From: Chris Westbury [REDACTED]
Sent: 18 October 2021 10:46
To: Planning.Responses; Nicola Moore
Cc: [REDACTED]
Subject: RE: Request for further information BR/240/21/PL
Attachments: Issue Sheet.pdf; PL01 rev A.pdf

Re: 9 Annandale Avenue Bognor Regis PO21 2ES BR/240/21/PL

PROPOSED SITE PLAN @ 1:200

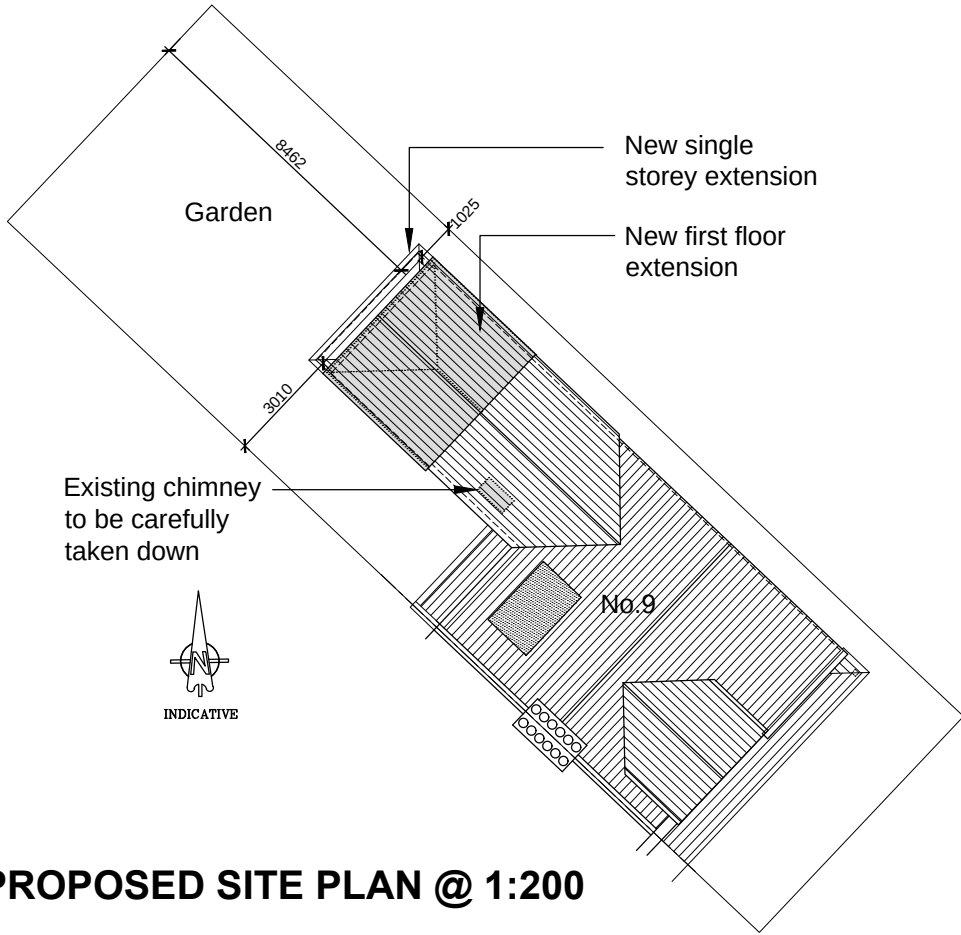
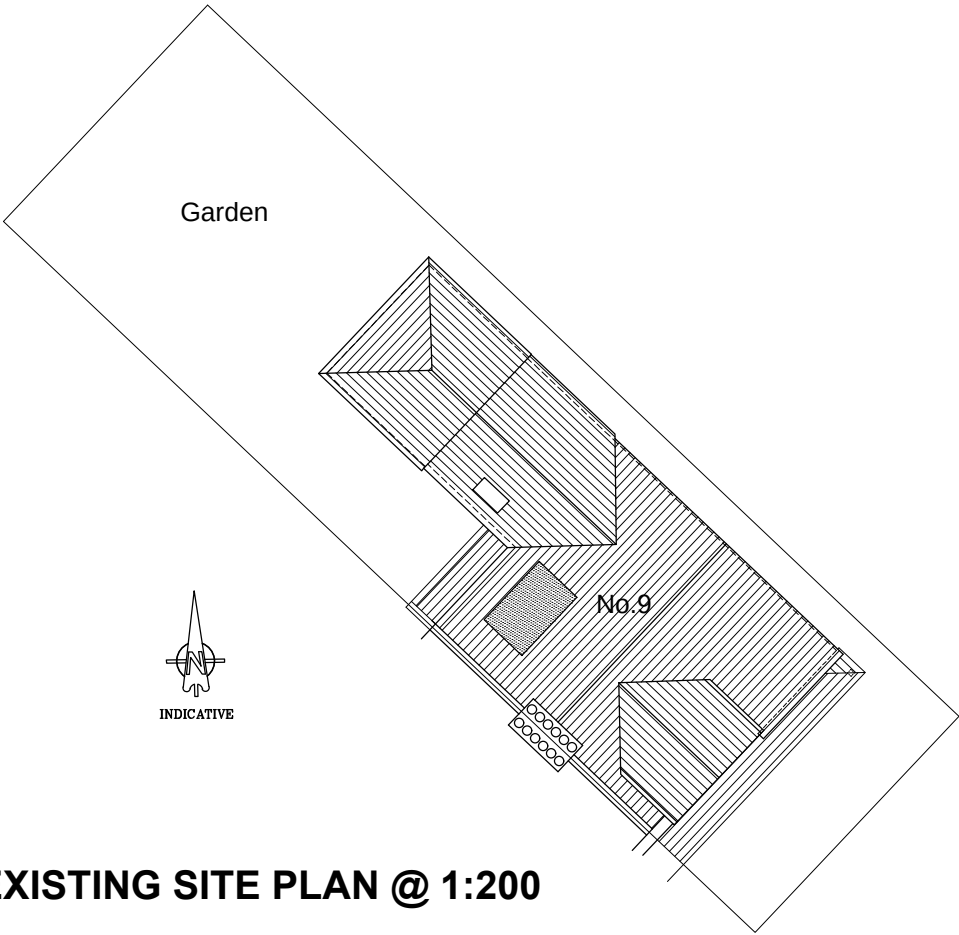
Further to your letter dated 15th October I have attached an amended site plan showing dimensions from the proposed extension to the boundaries.
